## **Thanet Extension Offshore Wind Farm**

### Appendix 5 to Deadline 6 Submission: Statement of Common Ground – Estuary Services Limited

Revision C

**Annex 10-2: Pilot Transfer Bridge Simulation
- Report**

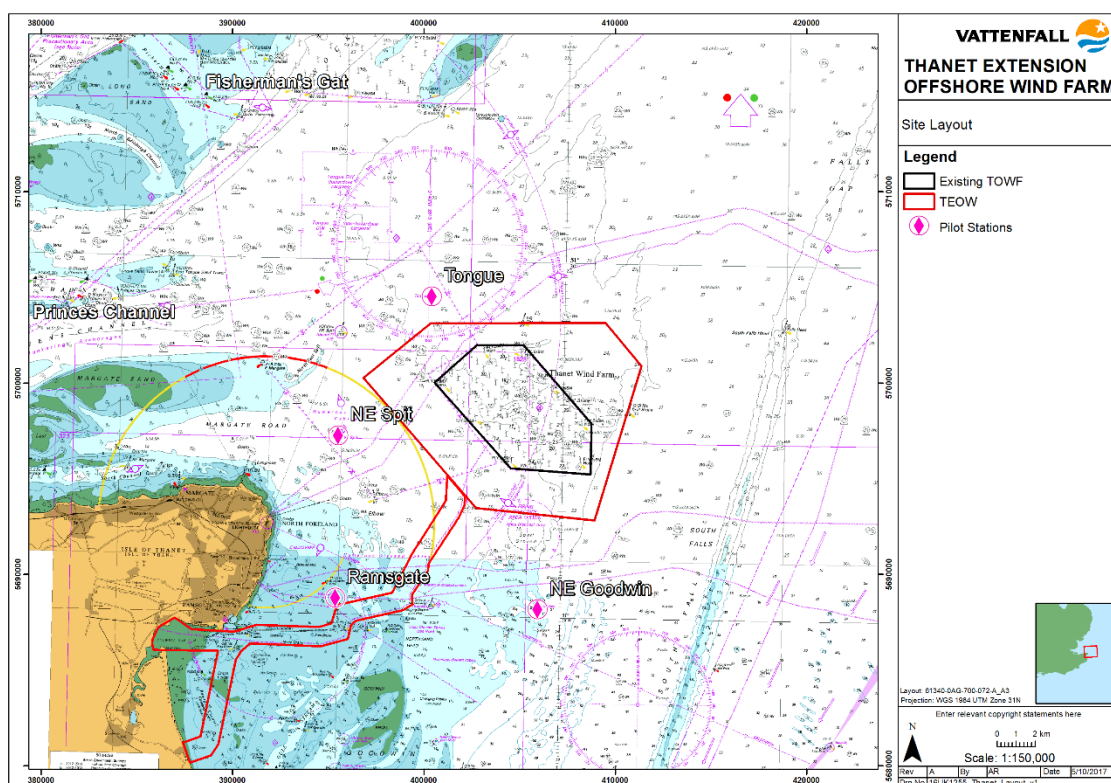
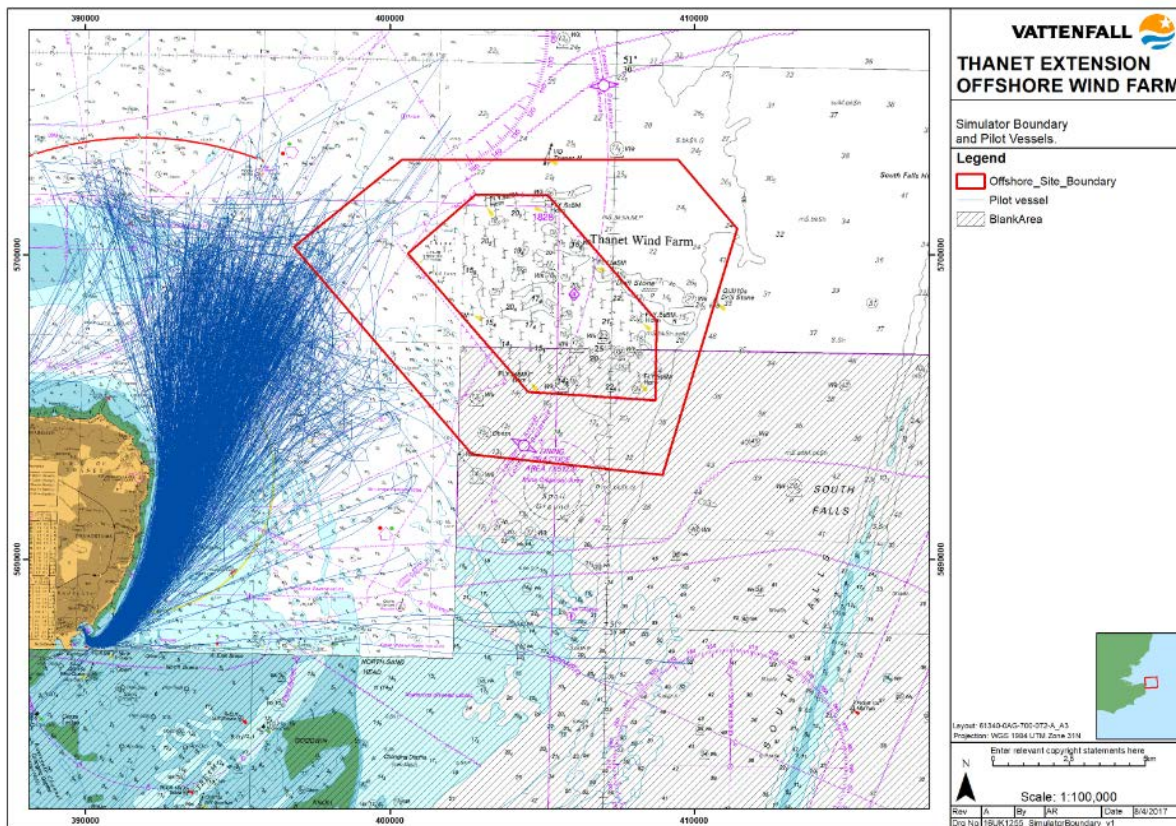
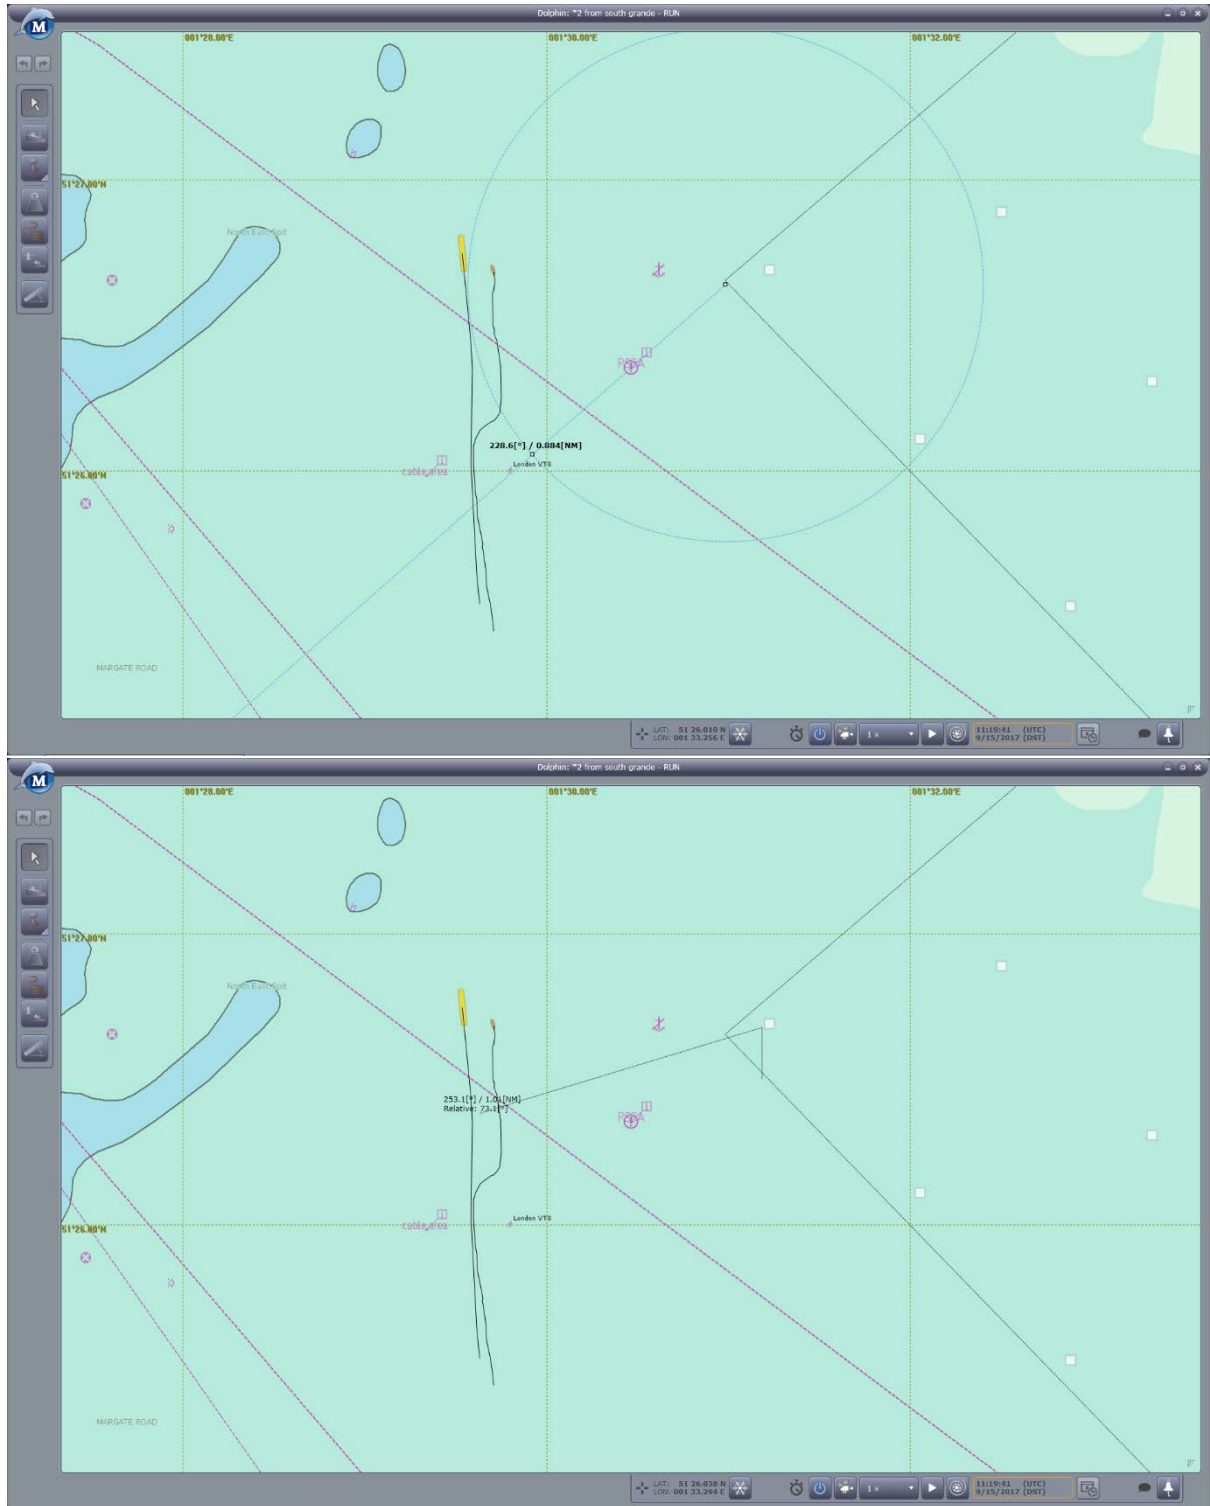
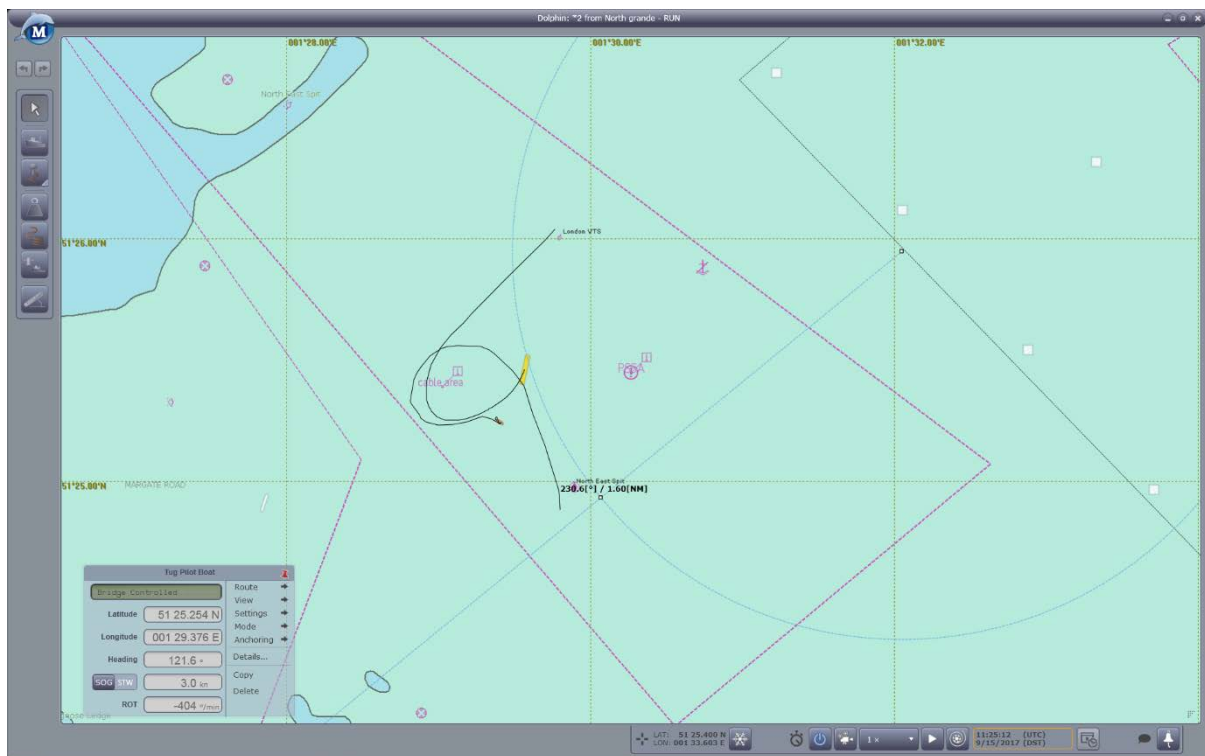
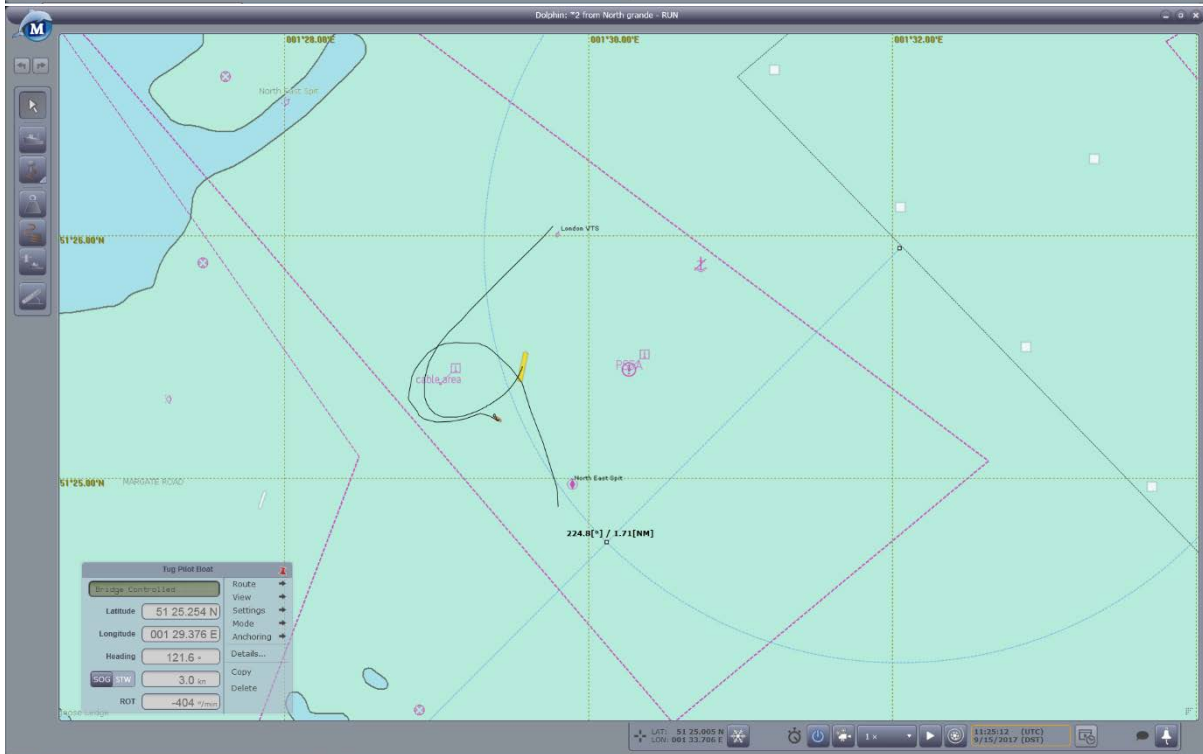
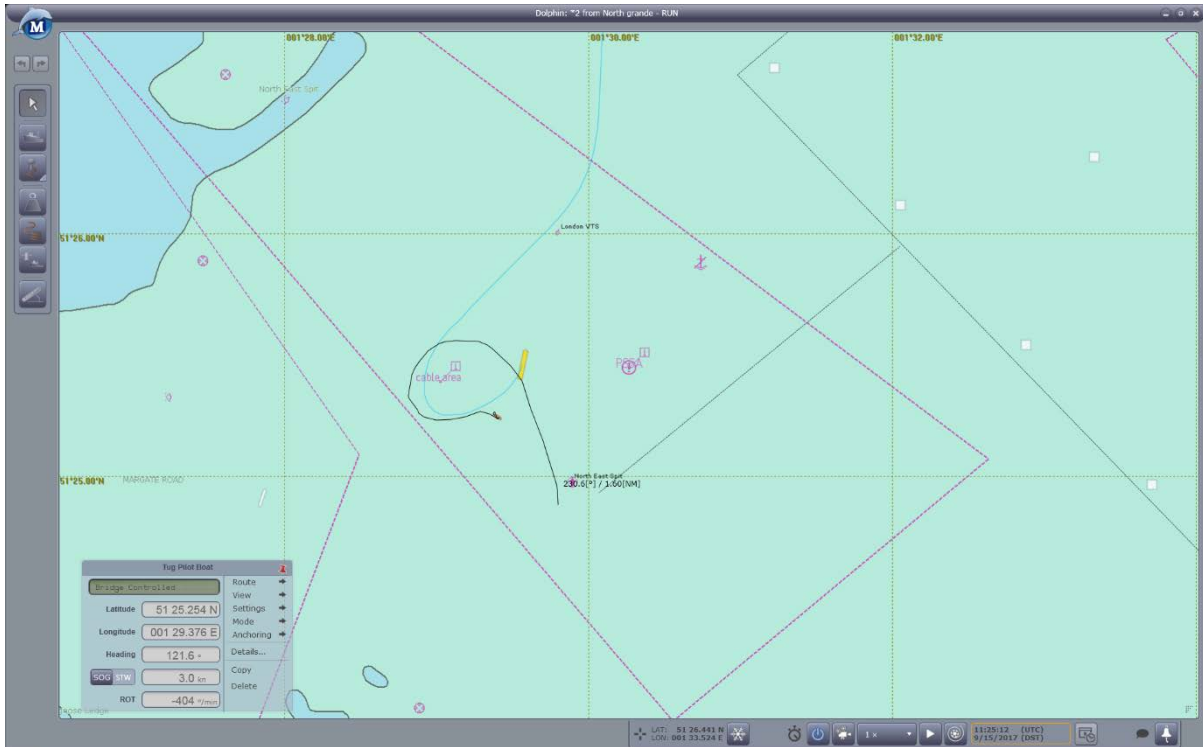
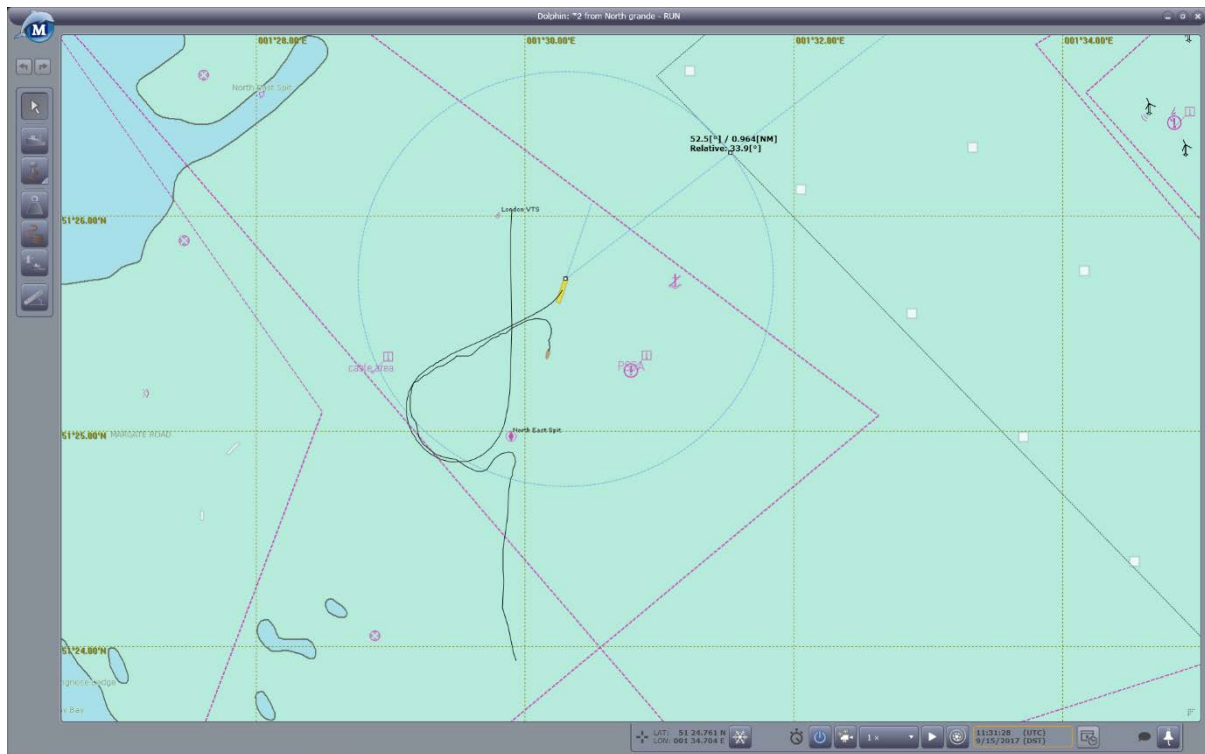
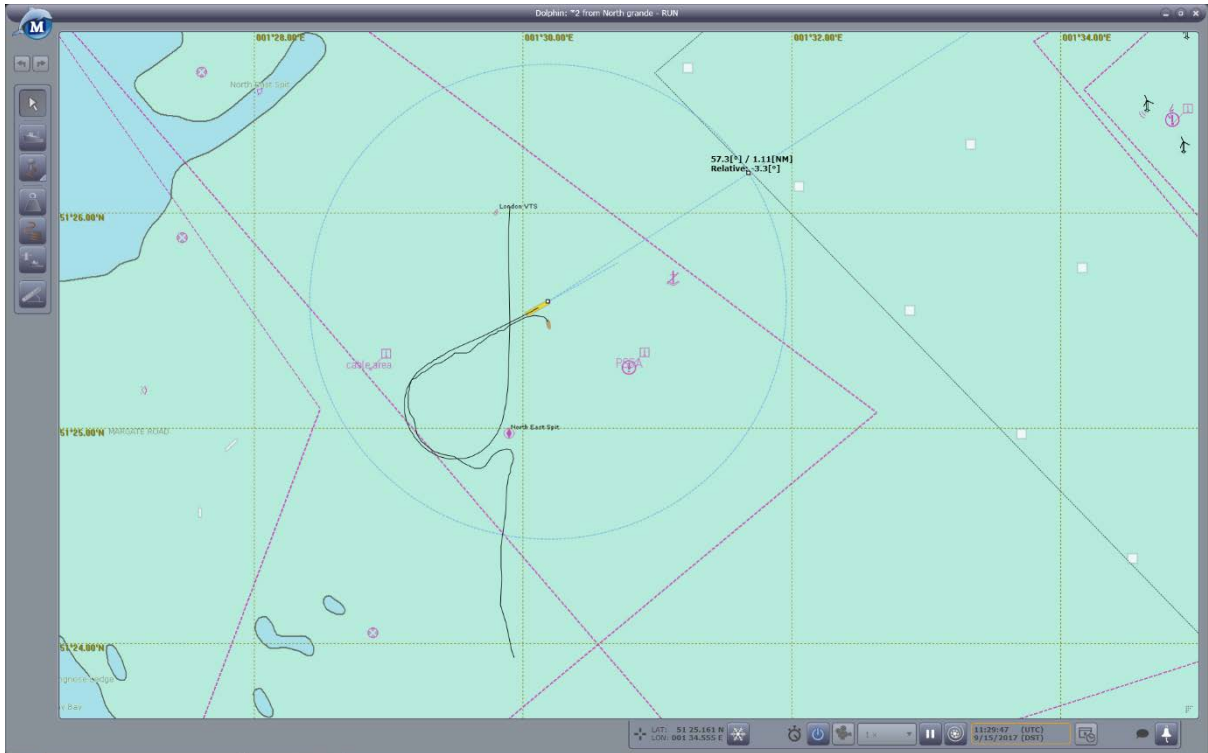
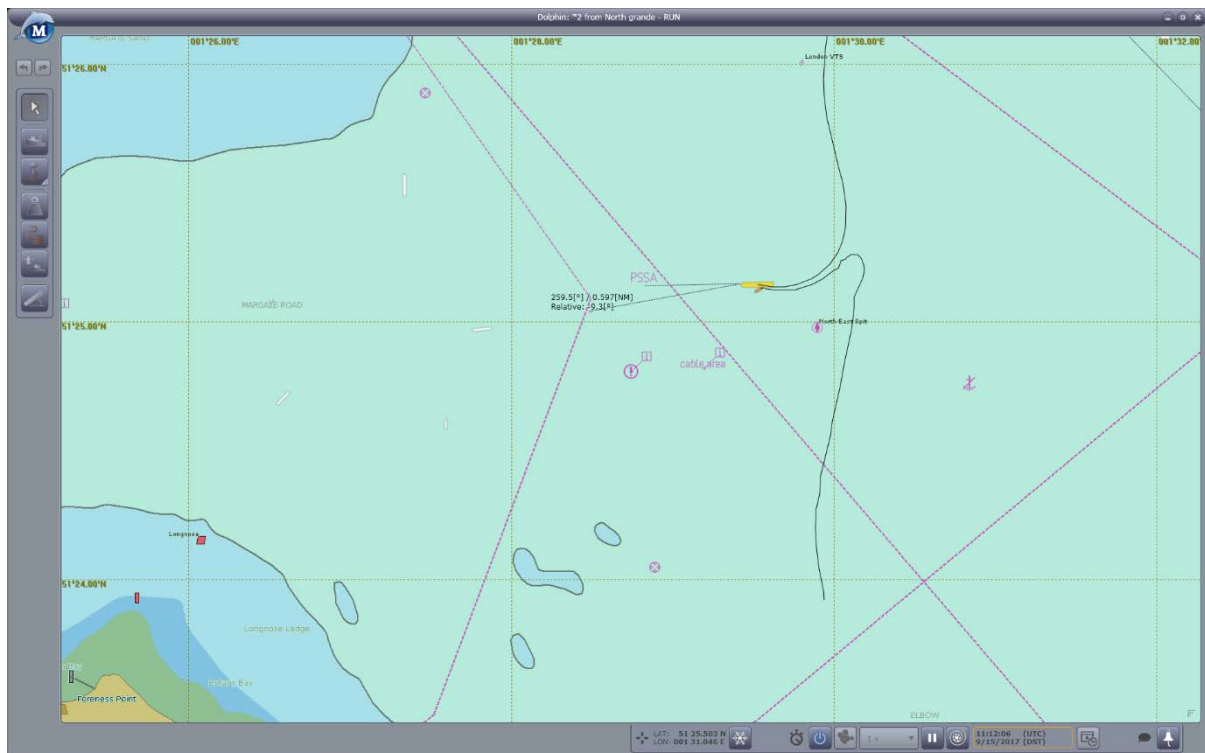
<p>Accompanying documentation</p>	<p>The bridge simulation exercise (Application Ref 6.4.10.2) accurately reflects the study undertaken with Port of London Authority and pilotage providers.</p>	<p>It is agreed that the study reflects the events that took place during the simulator exercise.</p>	<p>Agreed.</p>
<p>Accompanying</p>	<p>The bridge simulation exercise</p>	<p>ESL does not agree that the simulation exercise</p>	<p>Not agreed.</p>

<p><b>documentation</b></p>	<p>(Application Ref 6.4.10.2) accurately reflects the effects on pilotage associated with the original Red Line Boundary.</p> <p>The Applicant understands that ESL considers the weight afforded to the pilot simulation in the NRA to too great, however in accordance with Deadline 3 submissions, it does demonstrate feasibility.</p>	<p>accurately reflects the pilotage operation at the North East Spit for reasons previously explained ESL’s Deadline 1 submissions. Due to the limitation of this study ESL considers that the weight it is given in the NRA is disproportionate.</p>	
<p>NRA addendum - approach</p>	<p>The approach to the NRA addendum and the hazard workshop was presented to ESL in advance for comment. The approach taken by the Applicant is appropriate and matches NRA standard practice.</p>	<p>ESL was presented with a guide to the workshop in advance.</p> <p>As reflected in the MCA’s responses to ISH8 action point 10, ESL does not agree that it is standard practice to attempt such a significant NRA amendment under restricted time pressure. Given the level of agreement and understanding that is required for a risk assessment such as this, ESL does not feel the approach has been appropriate.</p>
